Application by Mona Offshore Wind Limited (the “Applicant”) for an Order Granting Development Consent for the Mona Offshore Windfarm (the “Project”)

COMMENTS ON DEADLINE 6 SUBMISSIONS AND FURTHER POST-DEADLINE EVIDENCE ON BEHALF OF:

IN CONNECTION WITH THE Application by Mona Offshore Wind Limited for an Order Granting Development Consent for the Mona Offshore Wind Farm

Figure 4.1: Sensitivity study array boundary options.

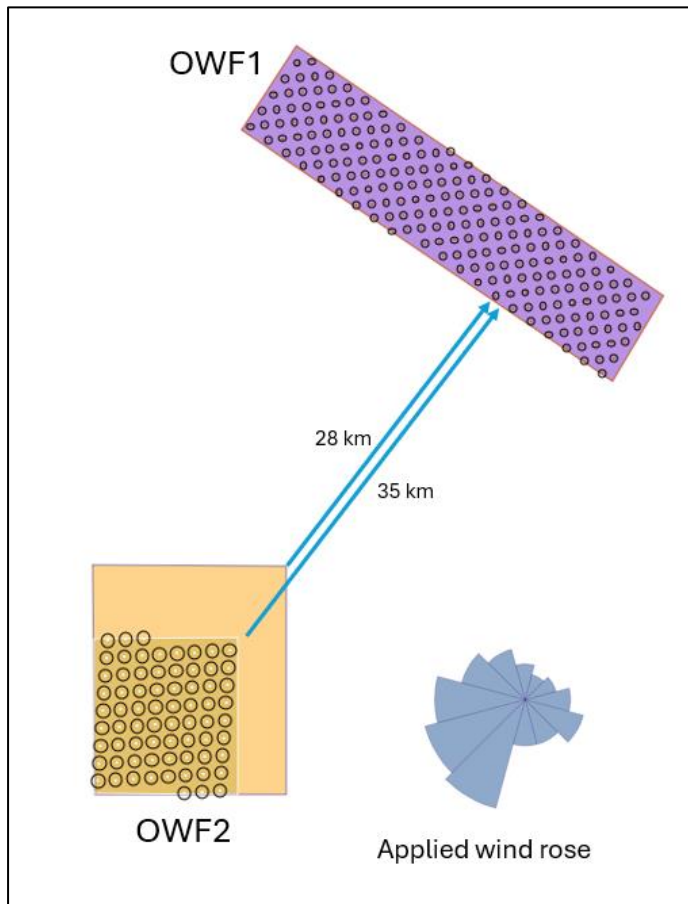
- 3.11 Scenario (c), which calculates one potential mitigation comparison for wake effects based on a “generic model”, is inappropriate as it draws broad conclusions without making use of readily available site-specific inputs or analysing real world mitigations.

- 3.12 The Applicant has undertaken a simple sensitivity analysis regarding separation distance, which deals with spatial mitigation only and ignores a number of other potential mitigatory measures.

- 3.13 The layout scenarios assessed reduces the Project’s array area by 50% and increasing the density of turbines within the array area (rather than removing any turbines). The Applicant has not modelled a scenario whereby the density of turbines is reduced, and has only provided a assessment of an extreme scenario.

- 3.14 As a result, the Applicant’s attempt to assess a scenario where the wake effects of the Project are mitigated is highly unrealistic. Therefore, it is not helpful in developing an understanding of realistic mitigation scenarios and does not assist in decision making.
